## APPLICATION BY AQUIND LIMITED

### DEADLINE 8: WRITTEN STATEMENT ON BEHALF OF THE UNIVERSITY OF PORTSMOUTH

1<sup>ST</sup> MARCH 2021

**Plate 4 - Typical Onshore Cable Route Cross-Section within Fields or Open Land (all measurements in millimetres)**

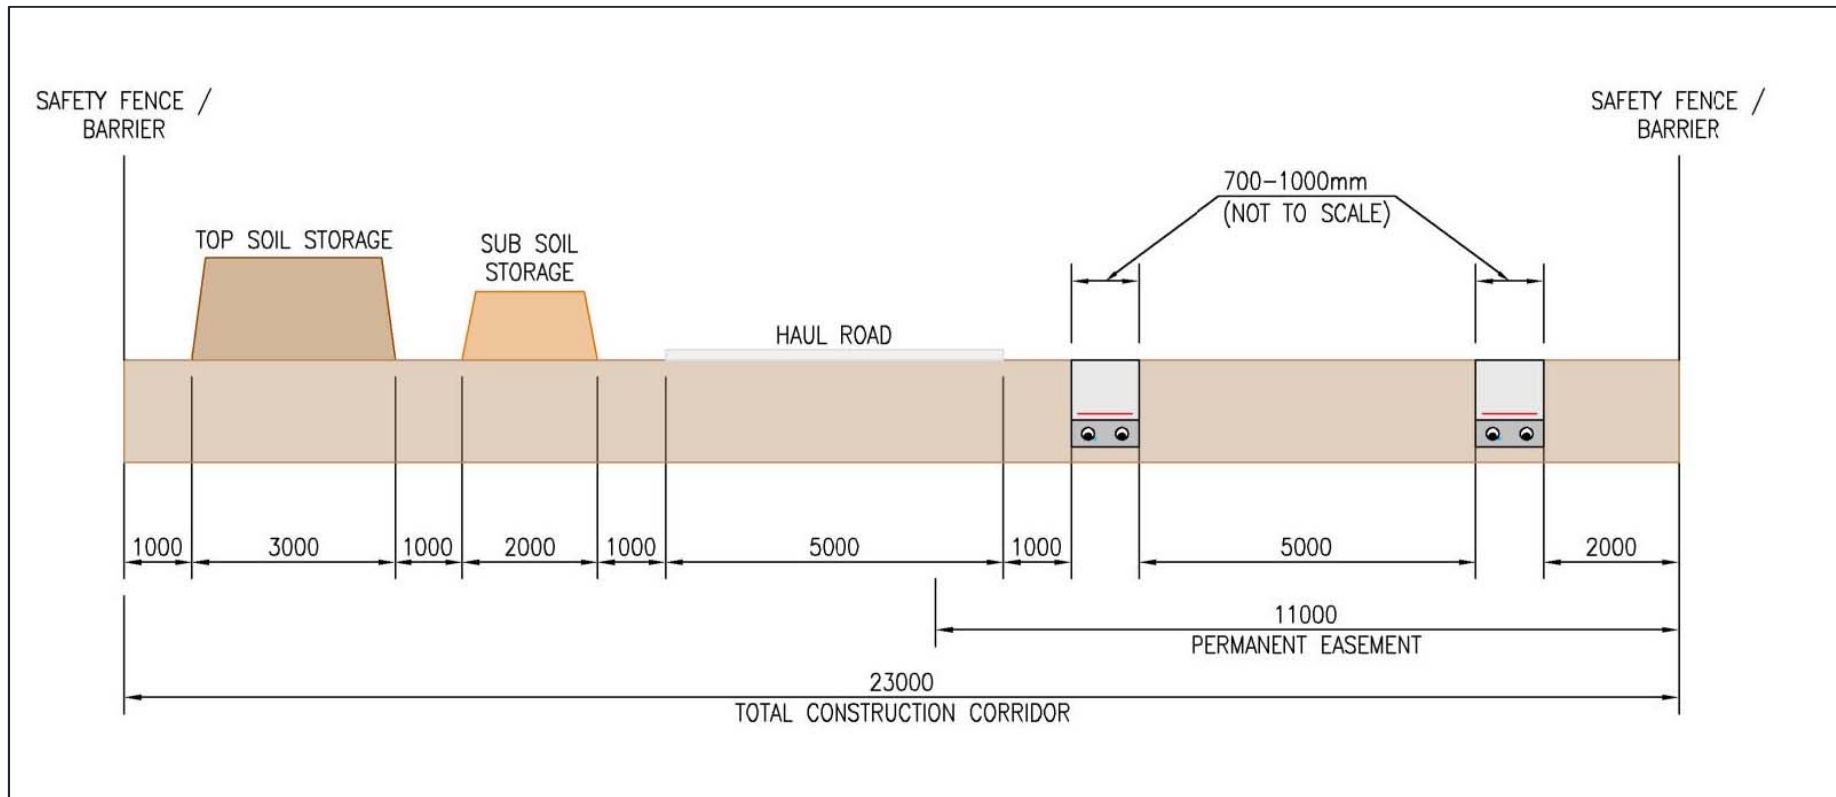
The haul road would result in a construction corridor approximately 23m wide. Without using the haul road it will be possible to reduce the construction corridor to approximately 10m wide. This would require reinstatement and the surveys taking place today will inform the best method and likely timescales.

**I have provided an indicative overview of the land required for the open trenching solution below. This would be subject to detailed design but is confirmed to be achievable from an engineering perspective. Given the construction corridor and easement widths are both approximately 10m wide I have shown this using a single area (shaded in blue below).**
